WEST SUSSEX COUNTY COUNCIL CONSULTATION

TO:	Arun District Council FAO:Mr. Simon Davis
FROM:	WSCC Highways - Public Rights of Way
DATE:	19 October 2021
LOCATION:	The Chalet Littlehampton Road Worthing BN12 6PG
SUBJECT:	FG/163/21/PL Development compromising marine workshop & boatyard, martial arts gym (Class E) & storage container compound (Class B8) to replace former glasshouses. This site is a Departure from the Development Plan & is in CIL Zone 3 (Zero Rated) as other development.
DATE OF SITE VISIT:	n/a
RELEVANT PUBLIC RIGHTS OF WAY NUMBER(S):	BW 2135
RECOMMENDATION:	More Information
S106 CONTRIBUTION TOTAL:	n/a

SITE PLAN 1:500 @ A3

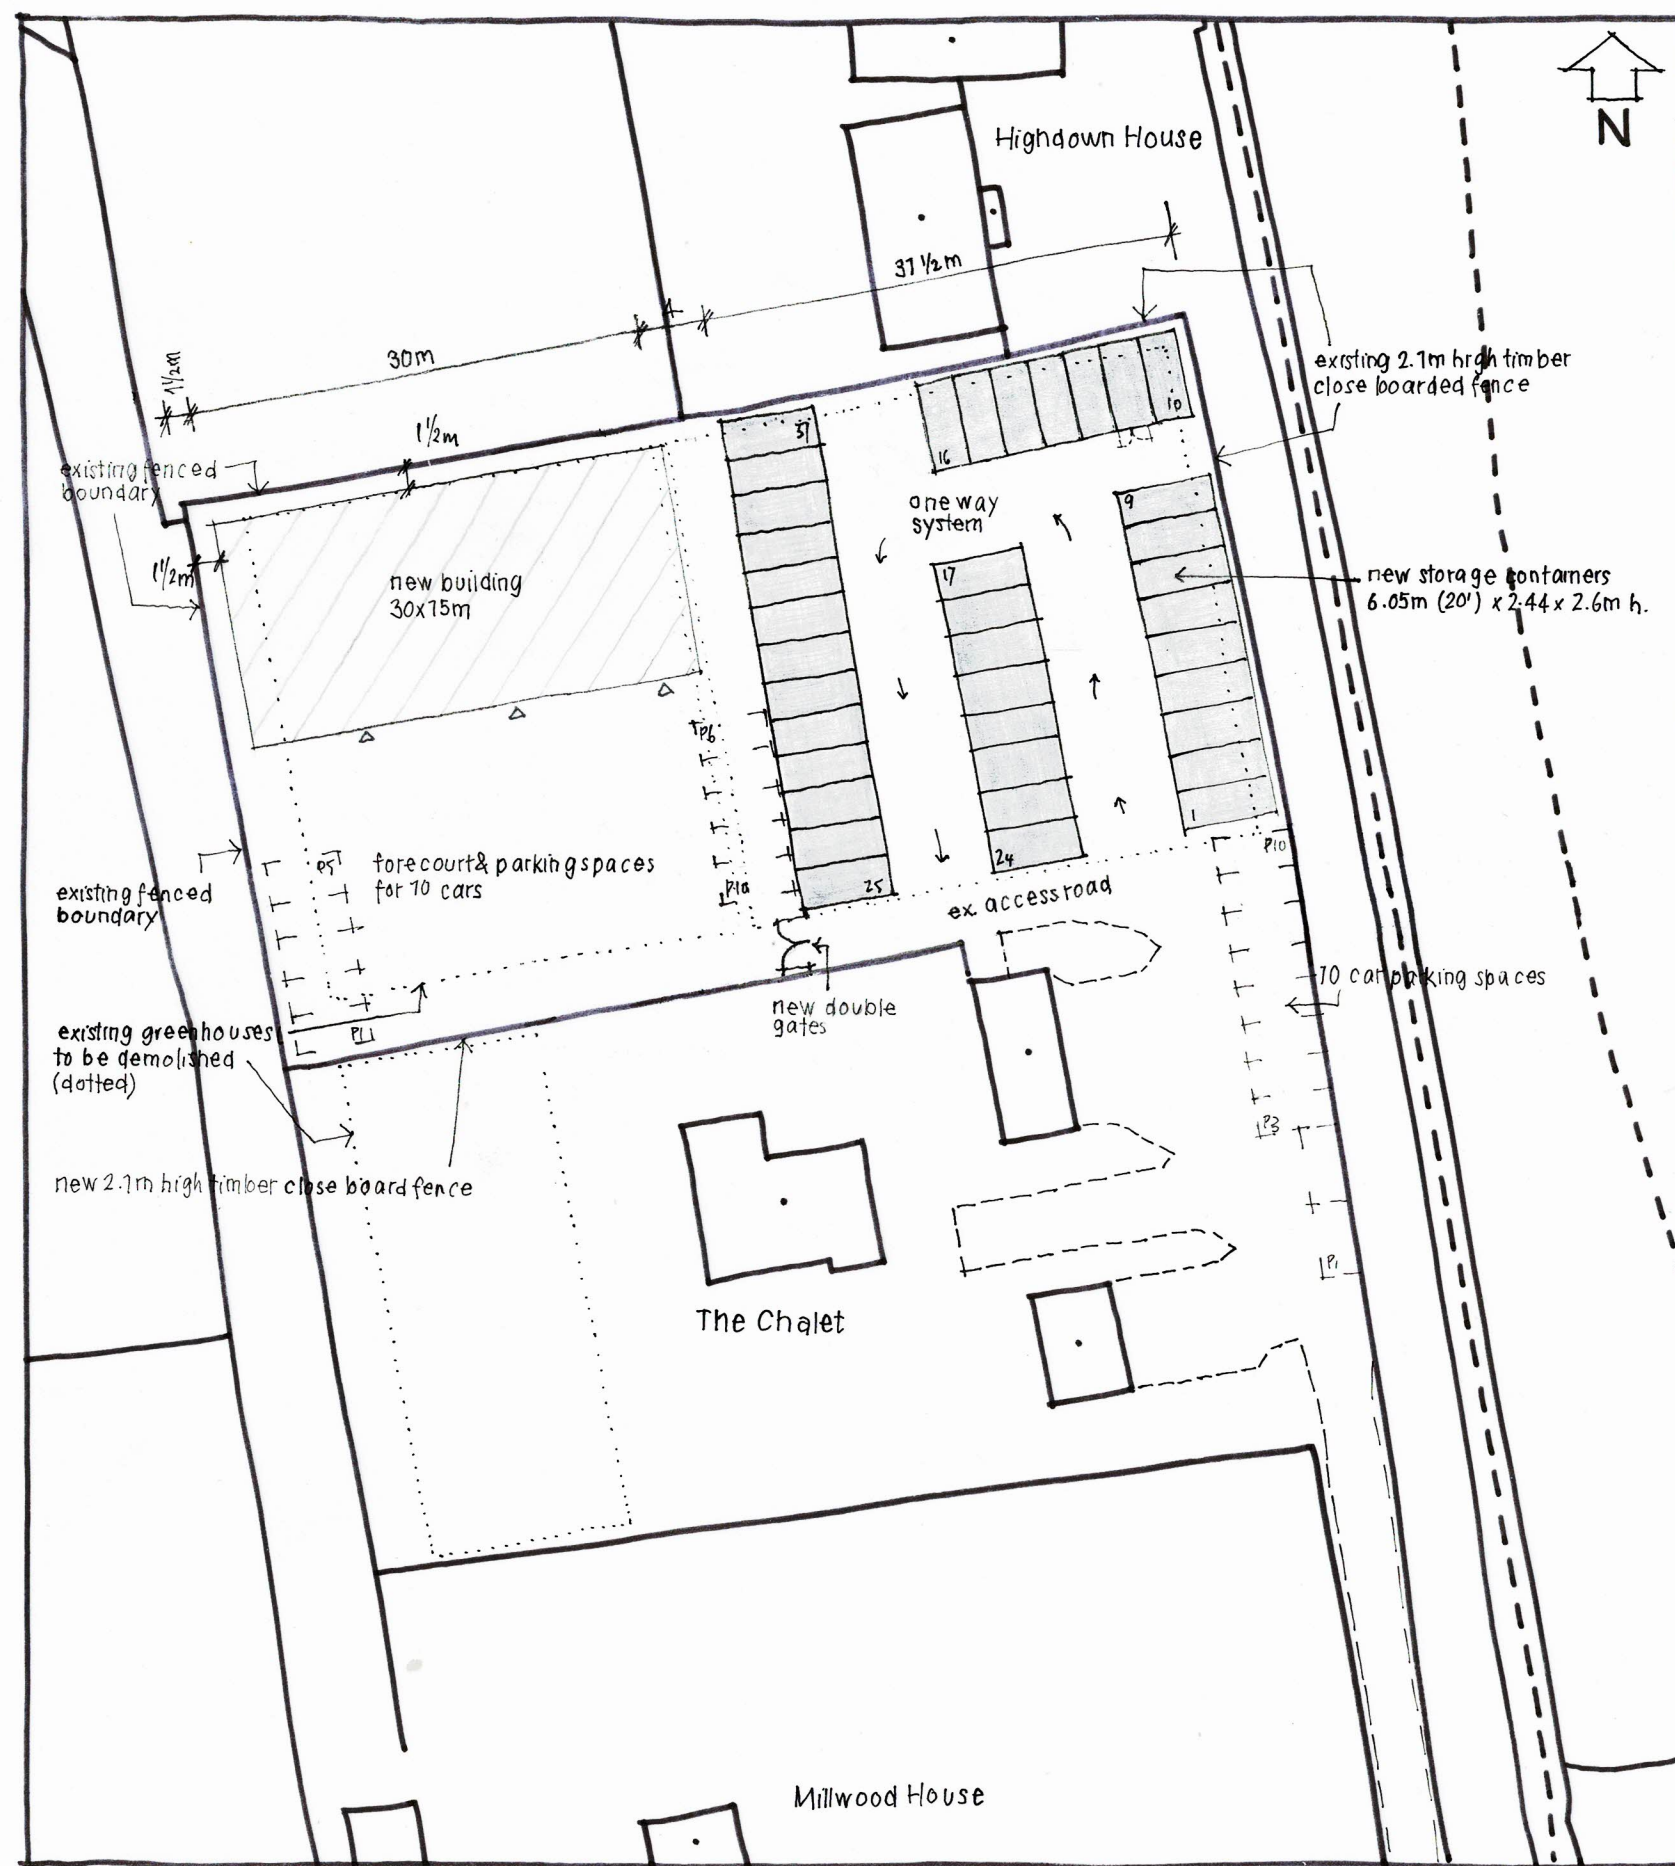
There is no reference in the applicant's documents or plans that access off the A259 and into their private driveway is via Bridleway 2135. This Public Right of Way is suitable for use by pedestrians, cyclists and equestrians. There is potential for conflict with any increase in large vehicles, particularly those with trailers, using this access. The safety of Public Right of Way users is paramount.

I note the applicant has been advised to withdraw their application so as to provide further information to and work with West Sussex County Council Highways. Firstly, can any future plans etc, show the presence of the Bridleway I would also be interested to note how many additional large vehicle movements they anticipate their boat and storage businesses will generate and during which hours of the week.
